# HyNet North West

## APPLICANT'S COMMENTS ON SUBMISSIONS RECEIVED AT DEADLINE 5

HyNet Carbon Dioxide Pipeline DCO

**Document Reference Number D.7.50**

Figure 6.1 – Extract of the Ince Park Plastics Masterplan - Drawing Number: 20039-FRA-XX-00-DR-A-90-0005 P2 approved under application no. 21/04076/FUL and works no.3, EN070007-D.2.4-WP-Sheet 1 [AS-012].

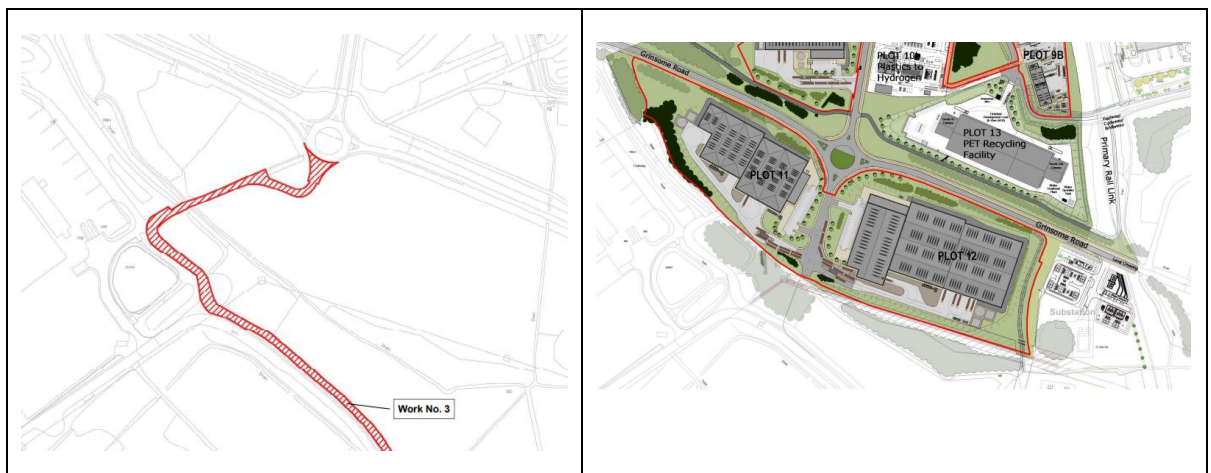
Previous Ref	WR Ref	The Council's Witten Representation (WR) Deadline 1	Applicant's Deadline 2 Comments	Council's Response at Deadline 3	Applicant's Deadline 4 Comments	Council's Response at Deadline 5	Applicant's Response
			<p>be captured and transported using the CO<sub>2</sub> pipeline.</p> <p>Looking further into the future, the CO<sub>2</sub> Transport Pipeline will be an asset for local industry and land owners and (as part of future developments and conditional on future consents being given) is likely to attract businesses to develop and/or expand their operations in the region, including the Protos Plastics Park.</p> <p>In general response to Economic Impact, the Applicant would like to draw the ExA's and CWCC's attention to the Applicant's Response to the ExA's ExQ1 at Deadline 1 <b>[REP1-044]</b> Q1.16.1 (Pages 106-107), which outline the economic benefit to the region the development will provide (as summarised in the text below):</p> <ul style="list-style-type: none"> <li>• <i>42,000 jobs created / maintained in North West England and North Wales</i></li> <li>• <i>Creation / maintenance of 55,000 UK jobs by 2030</i></li> <li>• <i>6,000+ UK Construction jobs in any given year until at least 2030</i></li> </ul>	<p>likely within the next couple of months, under application no. 22/03693/FUL, for the erection of an automated warehouse (Use Class B2/B8), ancillary office space, an automated link between the automated warehouse and existing facility, a driver welfare building, HGV marshalling yard, security building and other associated works.</p> <p>As shown below, the permanent access under dDCO Work No. 3 would cut through the proposed HGV parking area and would potentially affect the proposed access layout.</p>

Previous Ref	WR Ref	The Council's Witten Representation (WR) Deadline 1	Applicant's Deadline 2 Comments	Council's Response at Deadline 3	Applicant's Deadline 4 Comments	Council's Response at Deadline 5	Applicant's Response
				<p>Extract from Proposed site plan 12473-AEXX-XX-DR-A-0501 Rev P23 of application no. 22/03693/FUL</p>  <p>Work No.3, EN070007-D.2.4-WP-Sheet 1 (Rev D) [REP2-005].</p> <p>The Council would welcome engagement and constructive dialogue from the Applicant on these matters.</p>			
<b>Mineral Safeguarding</b>
